From: Jean Fraser
To: Tom Greer
CC: Lloyd, David; Mohr, Stephen; Tom Federle; Virginie Stanley; chip@new...
Date: 4/8/2014 5:03 PM
Subject: City comments on subdivision Plat- 118 Congress Street
Attachments: C1_0.pdf; approved S01 Subdivision Marriott Portland 03-15-13.pdf

The following comments are a compilation of Legal Department and DPS (including surveying) comments on the Subdivision Recording plat C1_0 (attached) as submitted March 27, 2014. I have pressed for these comments as the revised plat (that addresses these comments) will need to have a final review prior to signing by the planning Board.

SUBDIVISION RECORDING PLAT
C1.0

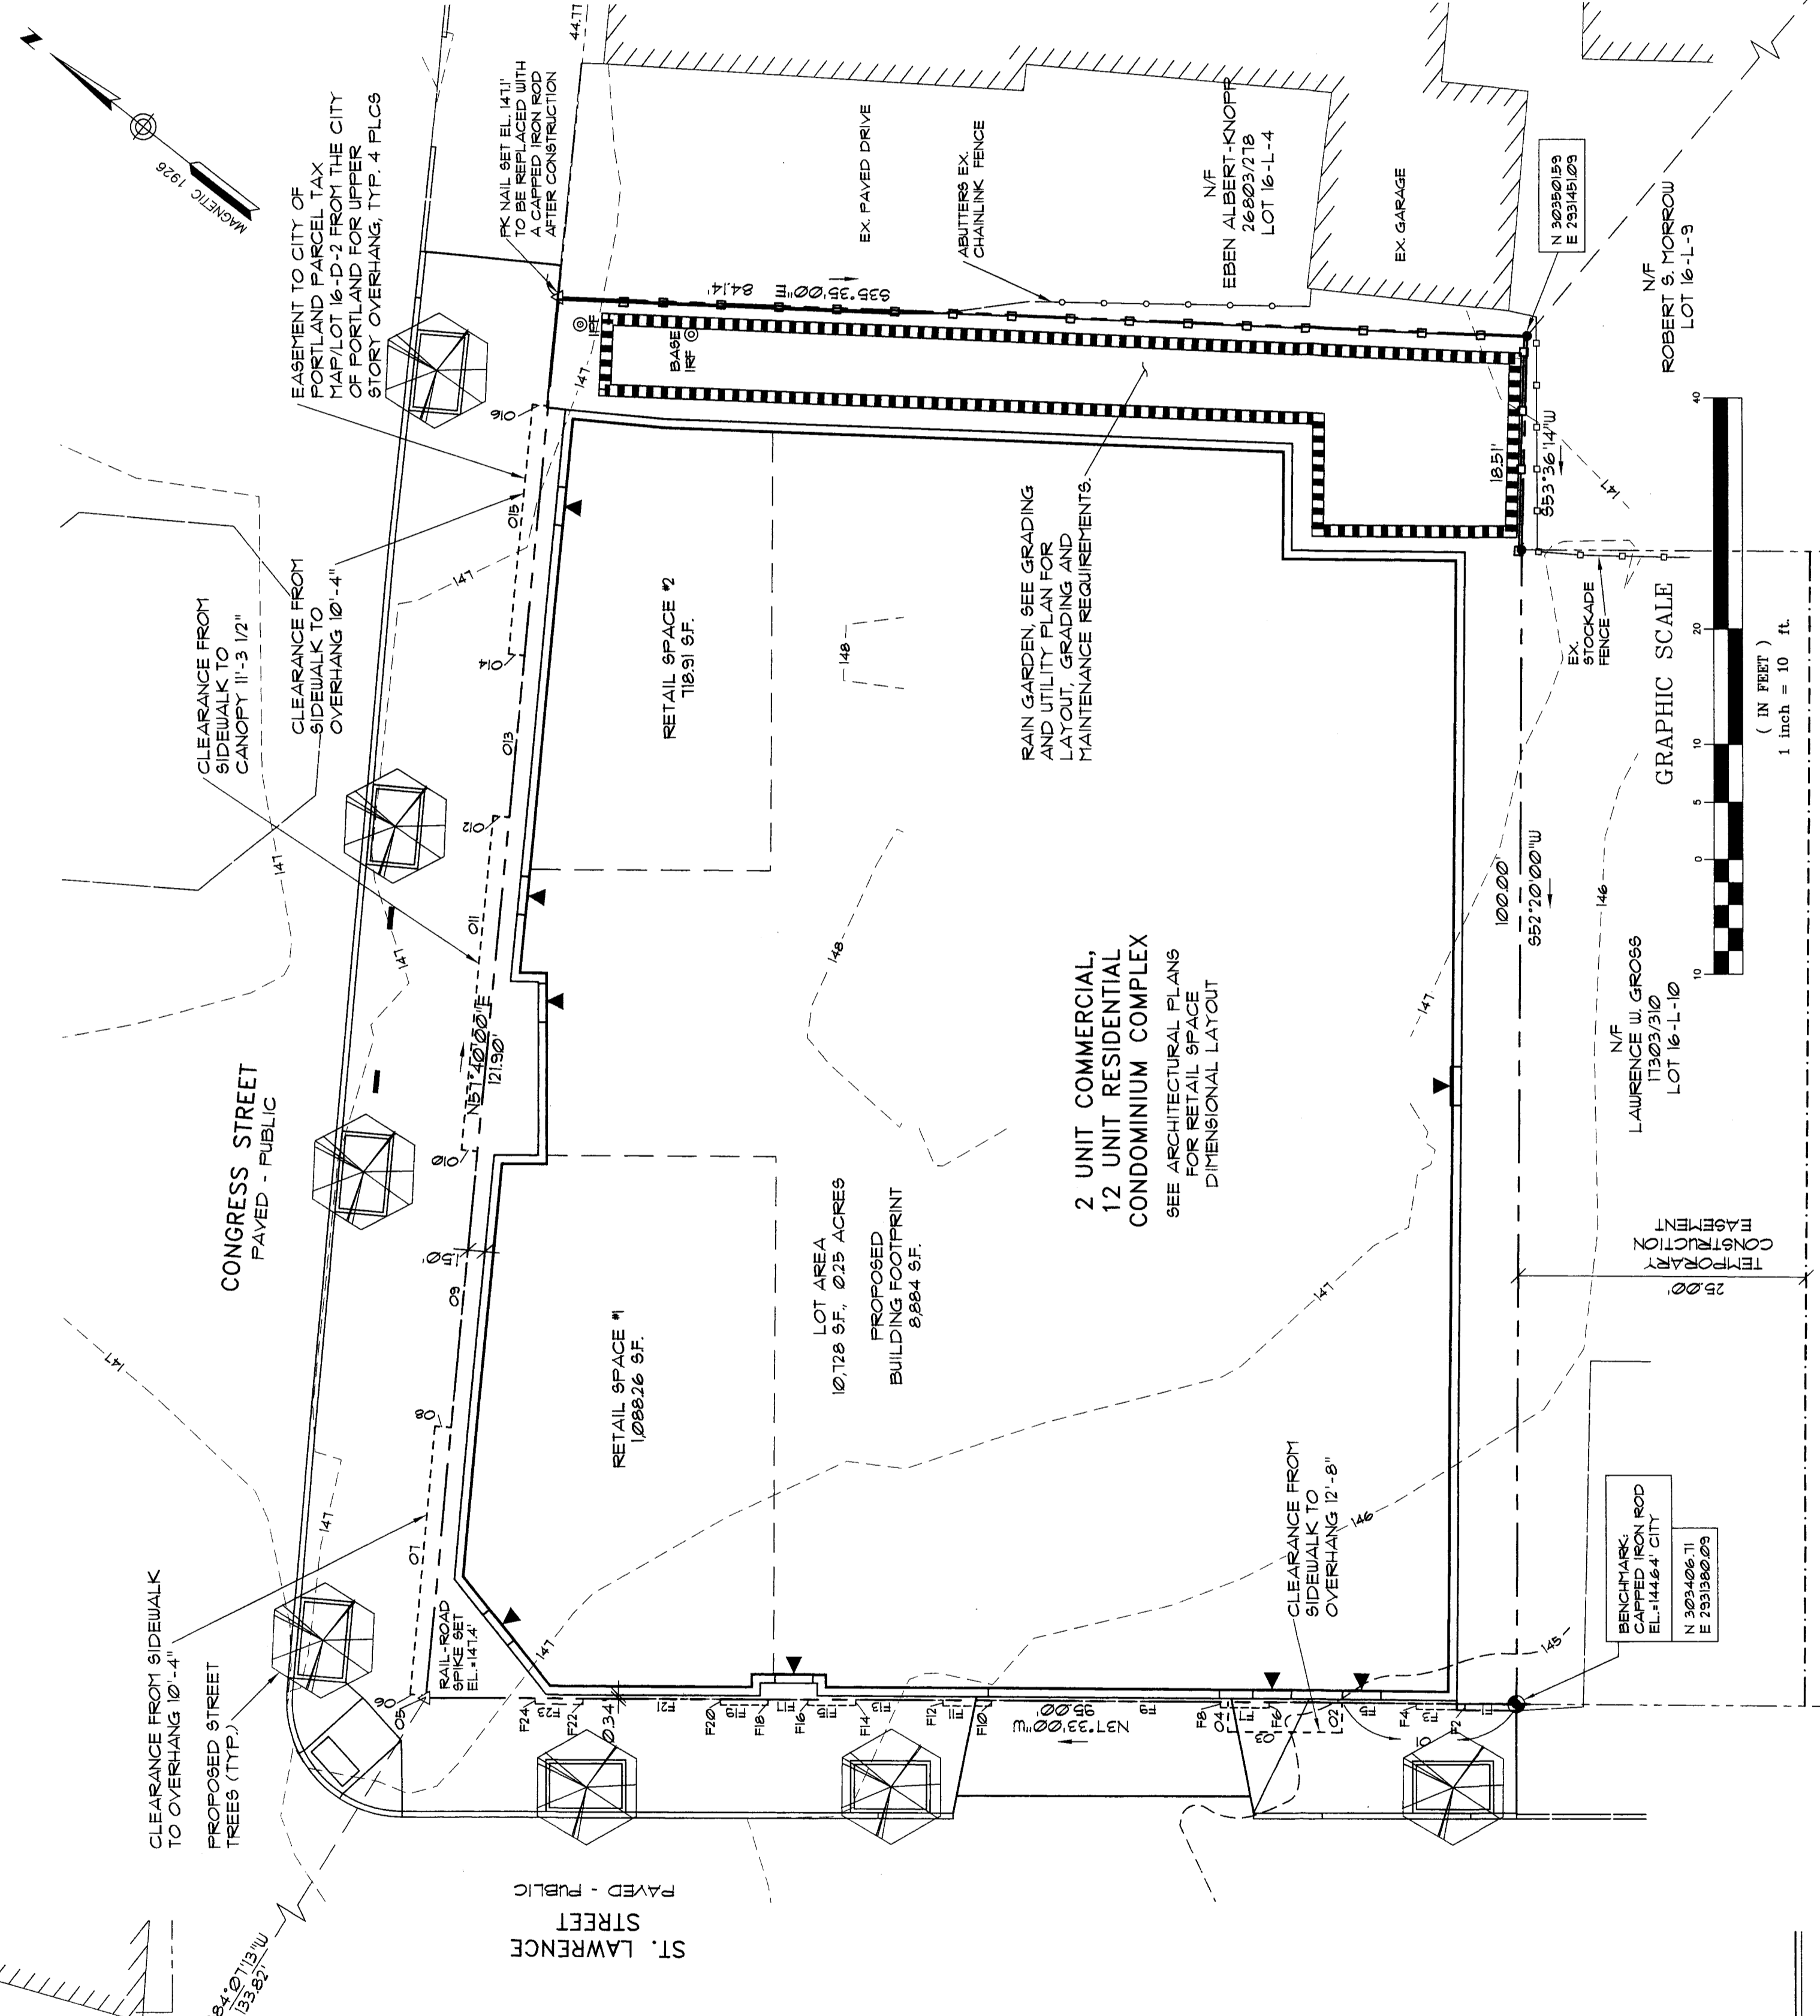
1. Notes need to be added to clearly spell out the responsibilities re the following:
Maintenance of rain garden, planting walls, street trees and treewells and substitute ROW materials
Snow removal
Trash removal
2. Show and label street trees (ensure locations are consistent with agreed locations on the Landscape Plan- comments to follow tomorrow)
3. Revise Note 16: to include location of parking, that it is for residential use only (I think that's what's in Condo Docs) and access.
4. Revise Note 18: include book and page of recording for condo docs
5. Remove Note 21 except for ref to Plan C1.4, as the plat nor the PB have determined that all conforms with the code and that's why the condition of approval is included.
6. Revise Note 22: the obligations of the association with respect to the licensed area should be included.

1. Three property corners need to be set along the southeasterly boundary.
2. State Plane Coordinates need to be added for the most southerly and easterly corners.
3. We note that a rail spike and PK nail have been set at the two corners along Congress St. A rail spike stands out very well as a property mark. Does the PK nail have a surveyor's washer and PLS number on it? (so it will stand out as something significant).
4. Overhang Easements: Please state the clearance allowed from the sidewalk to the bottom of the overhang (ensure consistent with arch plans submitted for license and building permit).
5. Plat to be stamped by a Registered Land Surveyor.
